UNSW Biological Sciences Project Stage 2

Volume 12: Building Code Report

Design Development Report
BS2-LT161026

RE: BUILDING CODE OF AUSTRALIA ASSESSMENT
BIOLOGICAL SCIENCES PROJECT, BUILDING D26 STAGE 2 SSD APPLICATION (7865)

Drawing number
BS2-WB-AR-811 A

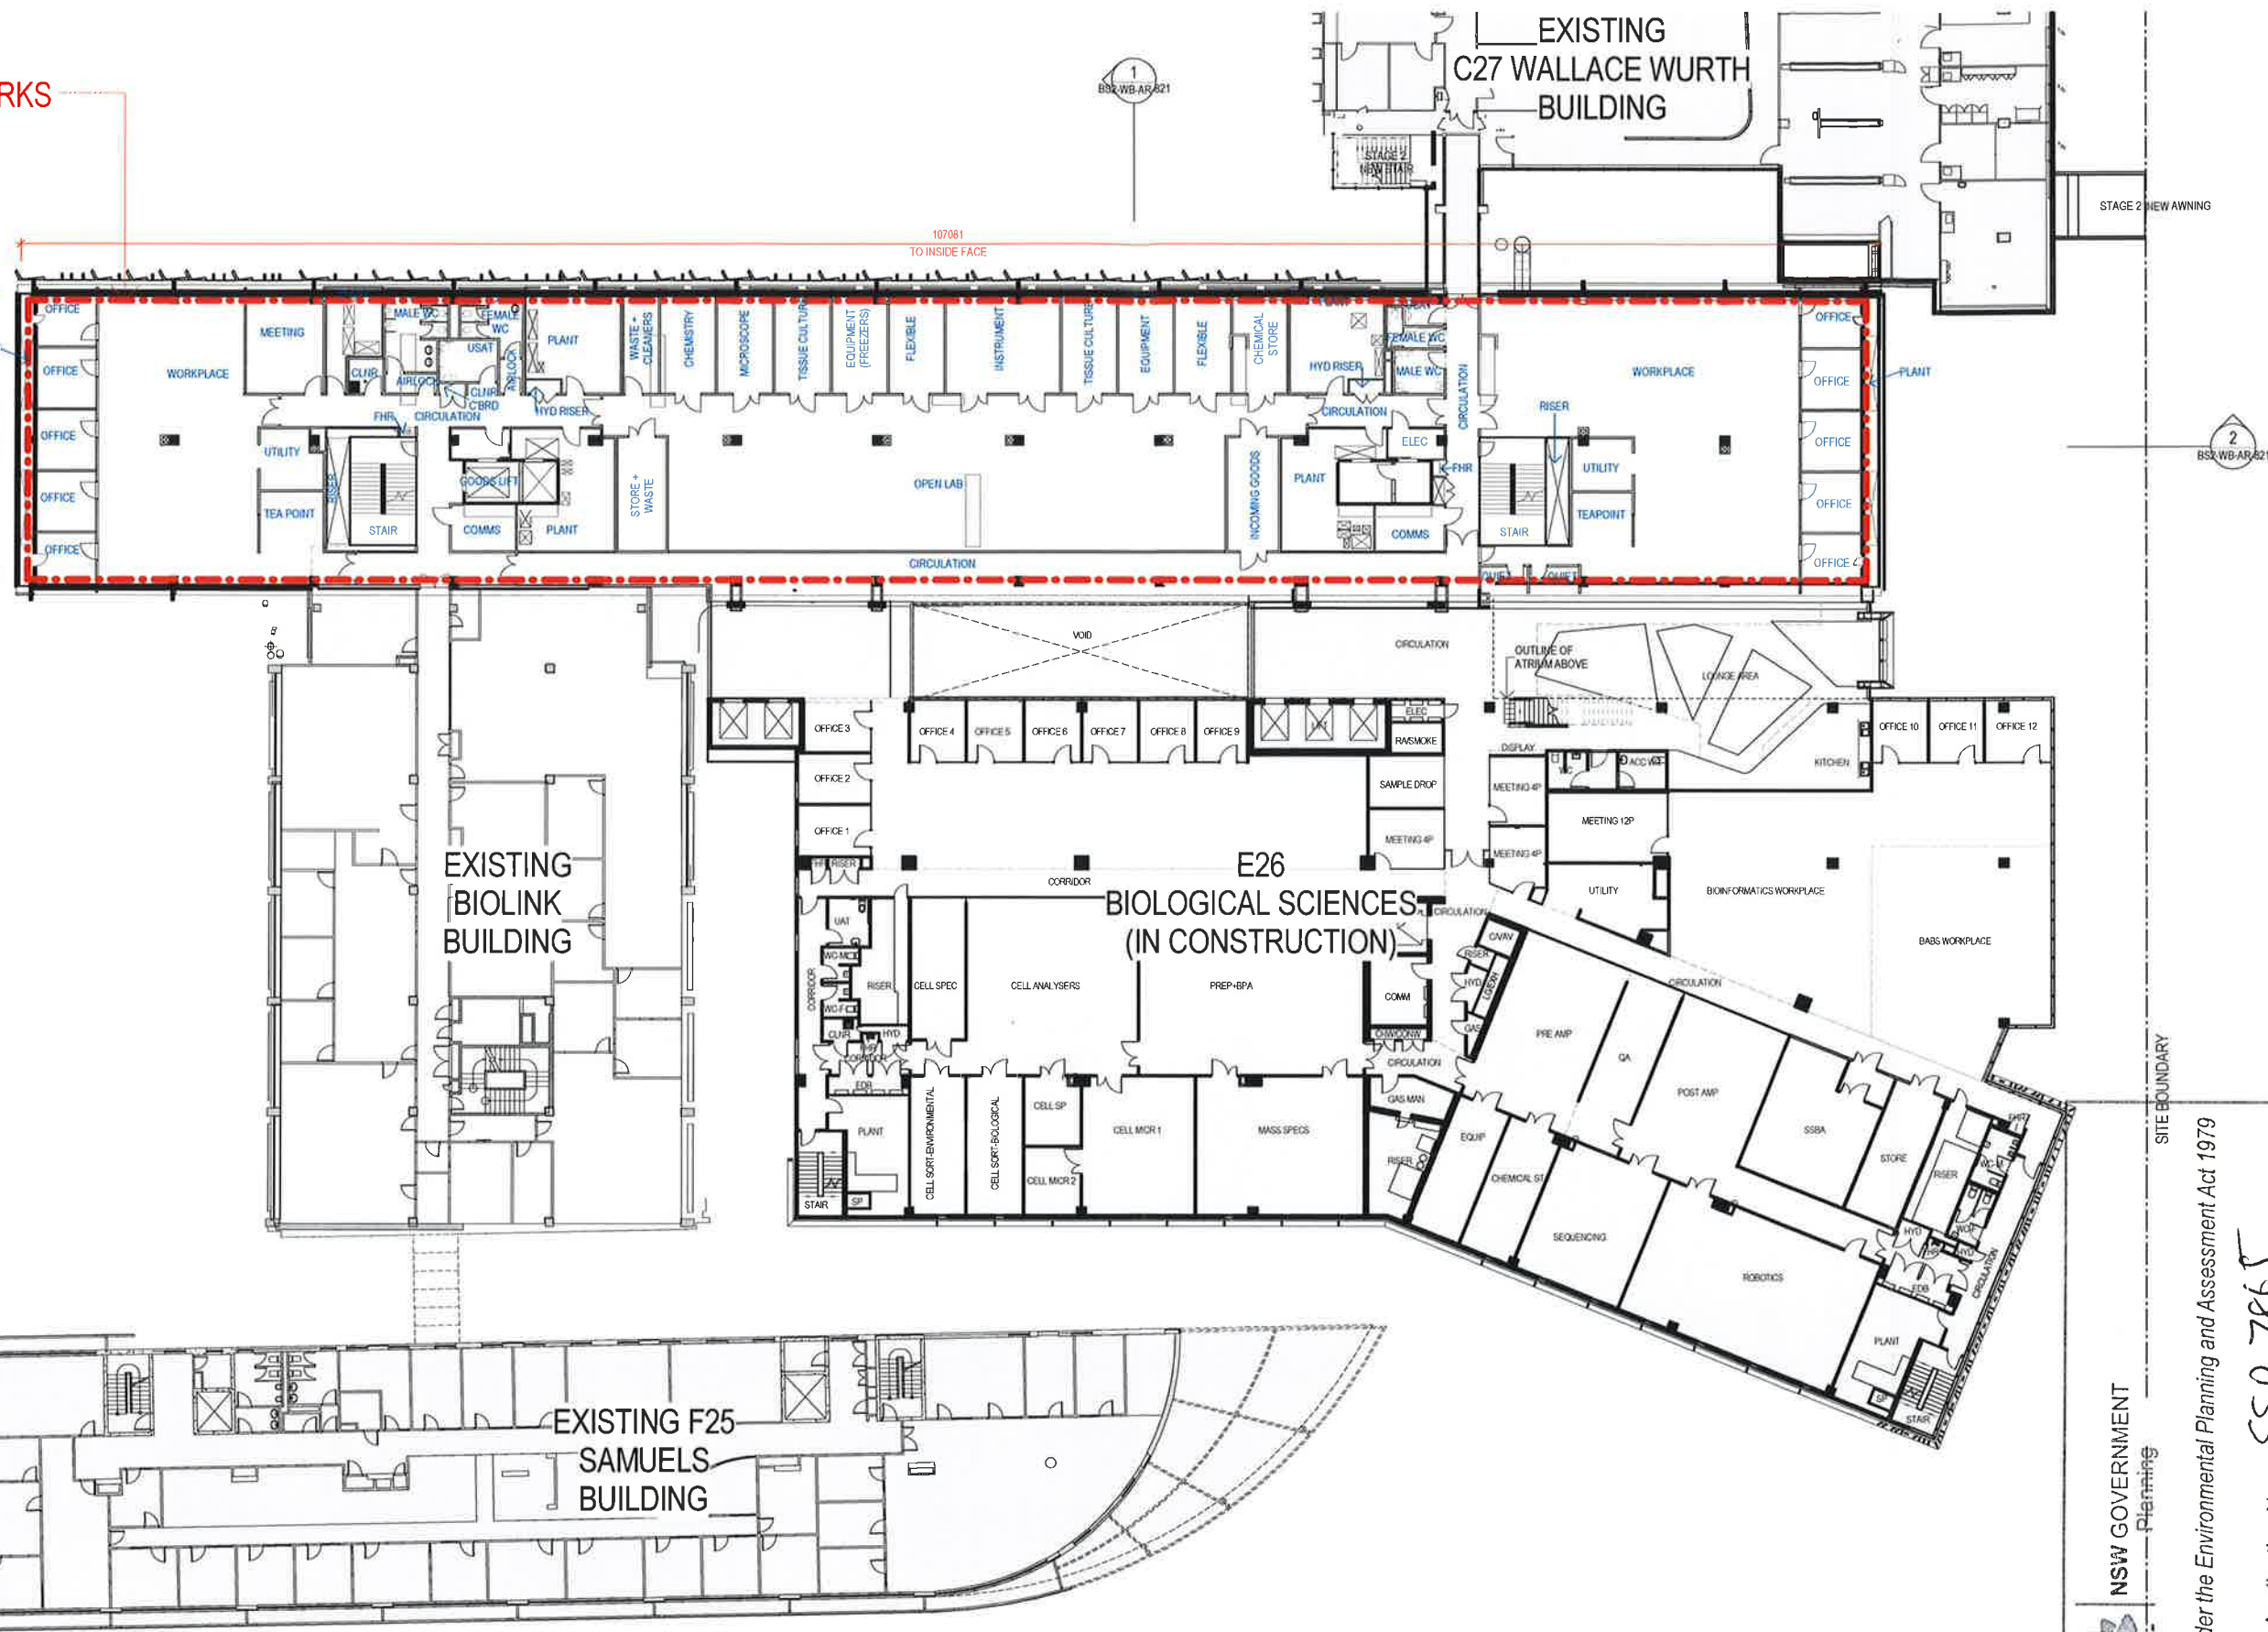
(b) L1, 2, 3, 4, 5 & 6 west exit to east exit – 61.5 m.

5.8 The location of the access door into Wet Teaching Lab 09 on Level 1, from the atrium, is to be located minimum 6 m from the entry door to the fire stair.
